**KIRKLEES METROPOLITAN COUNCIL
INVESTMENT & REGENERATION SERVICE**

DELEGATED DECISION TO DETERMINE PLANNING APPLICATIONS

| Site Address: | 3, Lower Hall Crescent, Lascelles Hall, Huddersfield, HD5 0AY |
| Description: | Erection of front dormer and associated alterations |

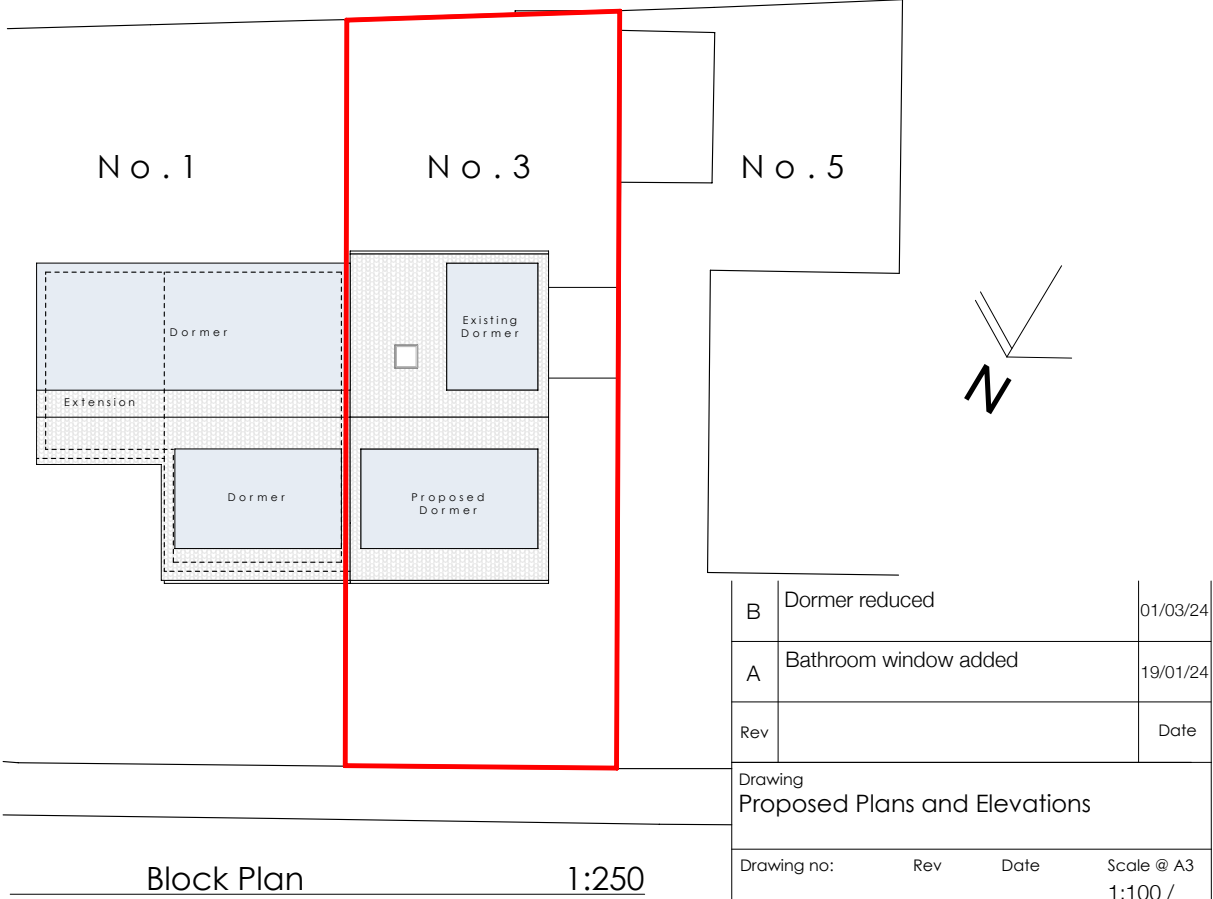
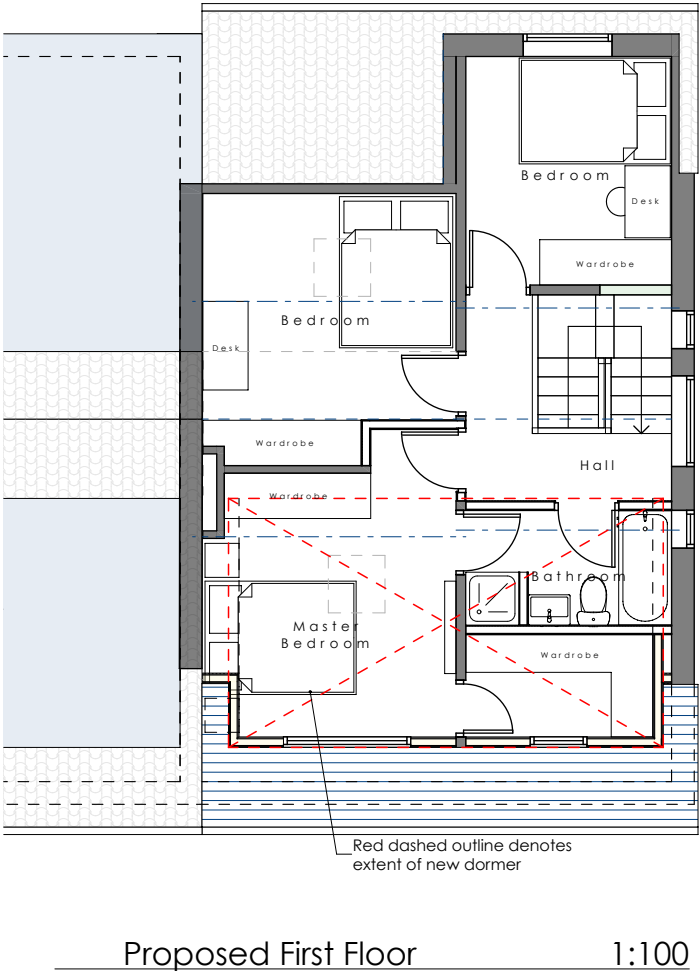
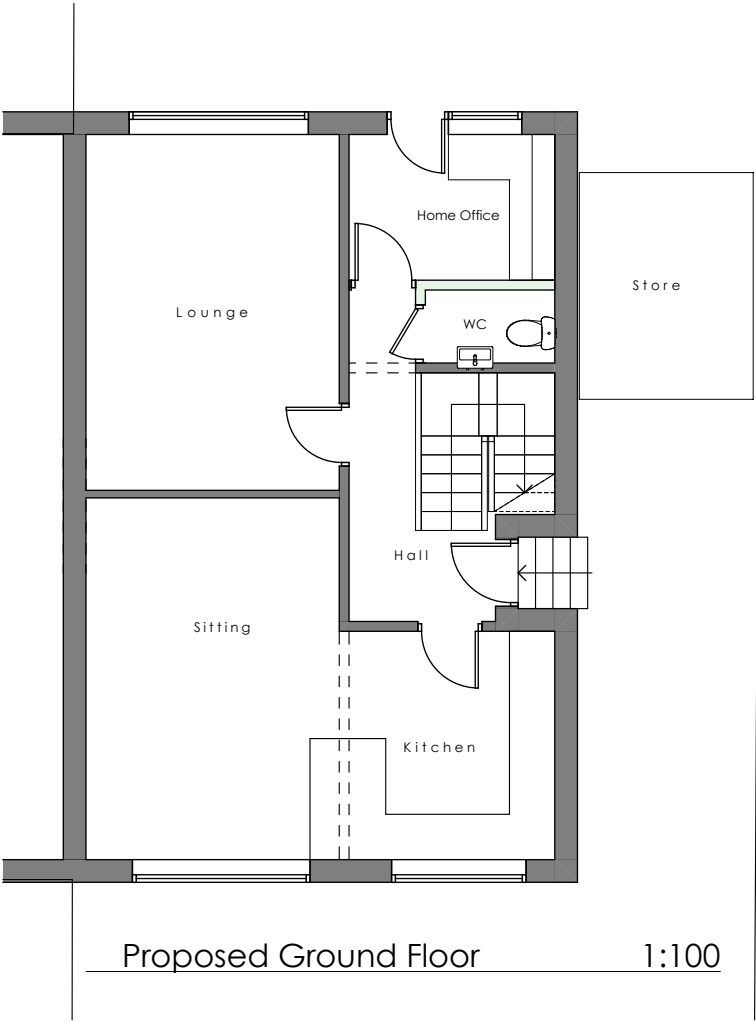
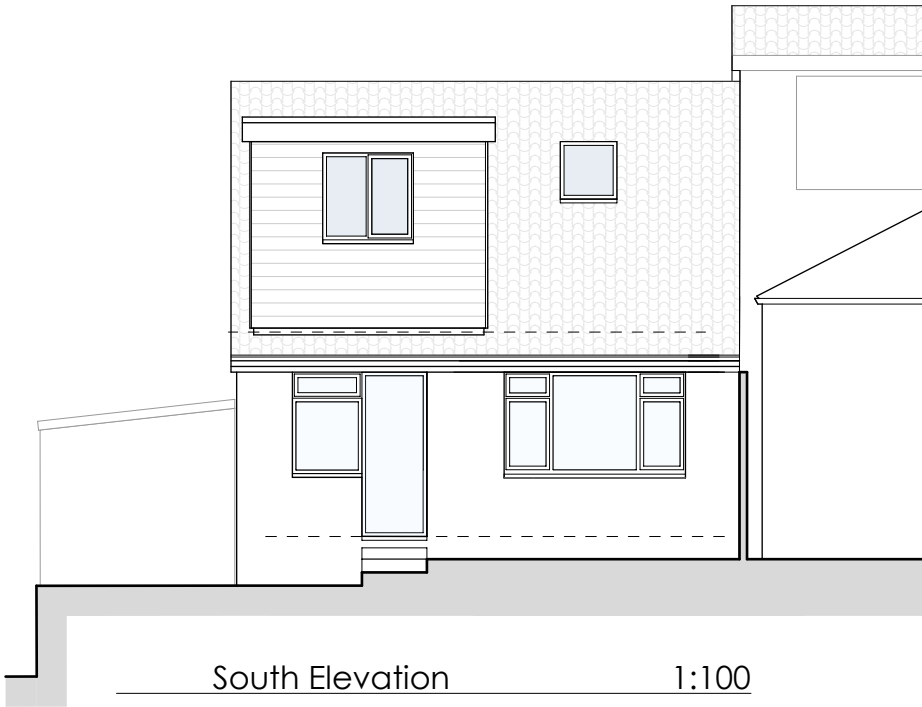
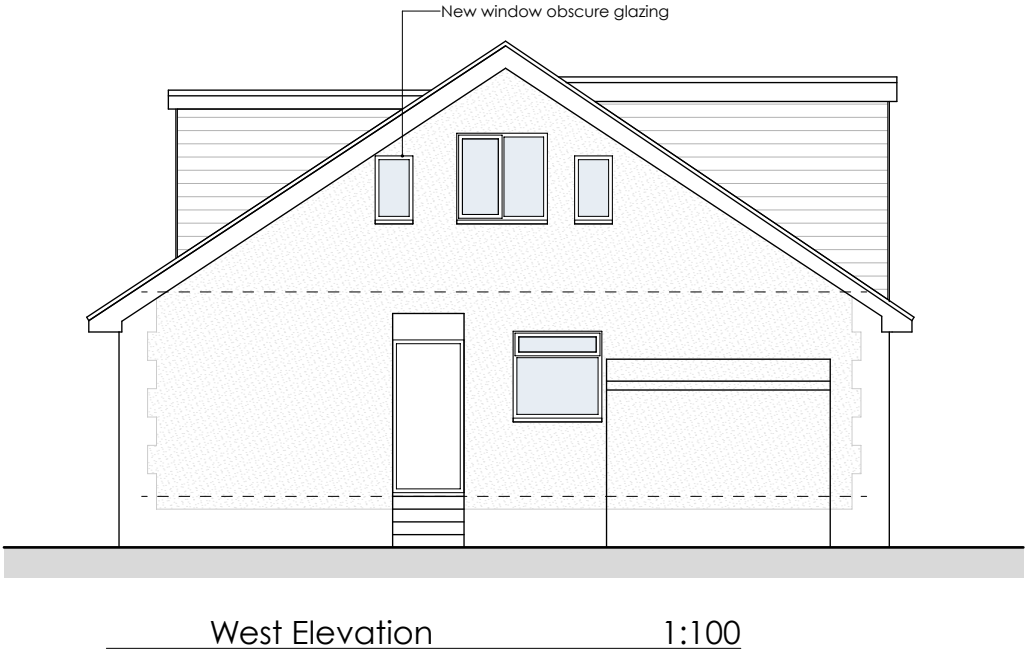
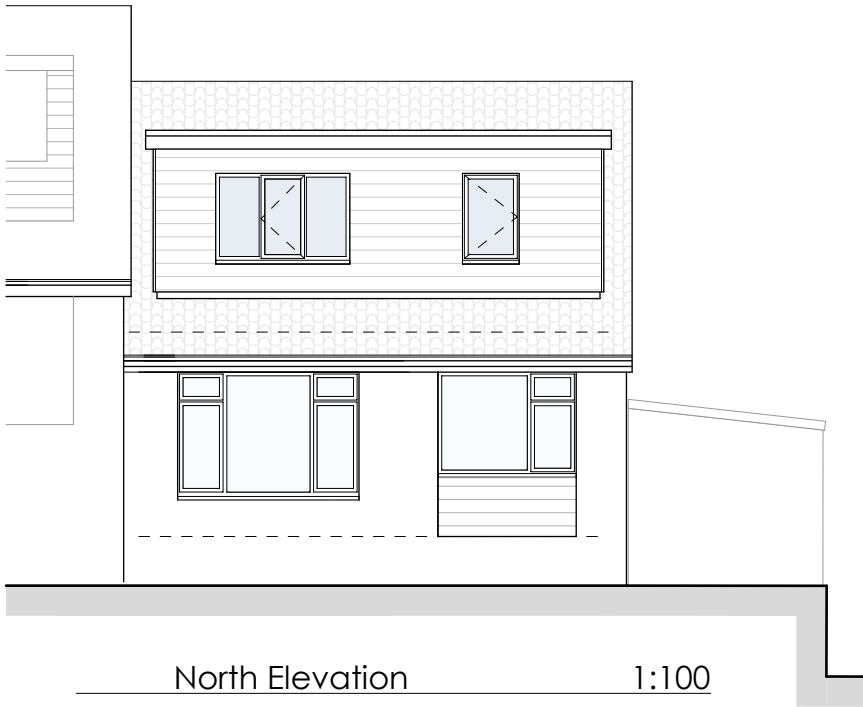
| | YES / NO | SUMMARY |
|--|-----------------|---|
| Negotiations/Amendments during course of application | Yes | Amended plans were secured showing a reduced front dormer to match the size of upper adjoined next door neighbour's front dormer. |

| SPD RECOMMENDATION: | <u>Yes - COMPLY</u> | <u>No - JUSTIFY</u> |
|--|--|--|
| be aligned with existing dormer windows on neighbouring properties in the same roof plane where relevant | Amended plans were sought in which the proposed dormer at No. 3 would be similar in size to the adjoined neighbour, 1 Lower Hall Crescent. | |

| | Relevant key design principle (KDP) of the SPD, Policy in the Kirklees Local Plan and the NPPF | Further comments | ✓ / X / N/A |
|--|--|---|----------------------------|
| Impact on original house | <ul style="list-style-type: none"> • KDP2 of the SPD • Policy LP24 Design (c) and (d) of the KLP • Chapter 12 of the NPPF | Amended plans have been submitted in which the front dormer is reduced in scale and proportionate to the existing dwellinghouse. | ✓ |
| Height, scale and massing | <ul style="list-style-type: none"> • KDP 1 and 2 of the SPD • Policy LP24 Design (a), (c) and (d) of the KLP • Chapter 12 of the NPPF | The dormer would be sited ~1 metre above the eaves and ~0.6 metres below the ridge of the dwelling. It is therefore considered that the dormer would not dominate the roof and is acceptable in the amended form. | ✓ |

5, Lower Hall Crescent is located adjacent to the application site on the south-west facing elevation. The first-floor window within the west-facing elevation would directly face this neighbour with a separation distance of ~6 metres. However, this window would be obscurely glazed which is acceptable in terms of mitigating detrimental harm to overlooking/ privacy of this neighbour.

| Plan Type | Reference | Version | Date Received |
|-------------------------------|------------------|----------------|----------------------|
| Proposed Plans and Elevations | 0155/ 2023 - 02 | B | 05/03/24 |
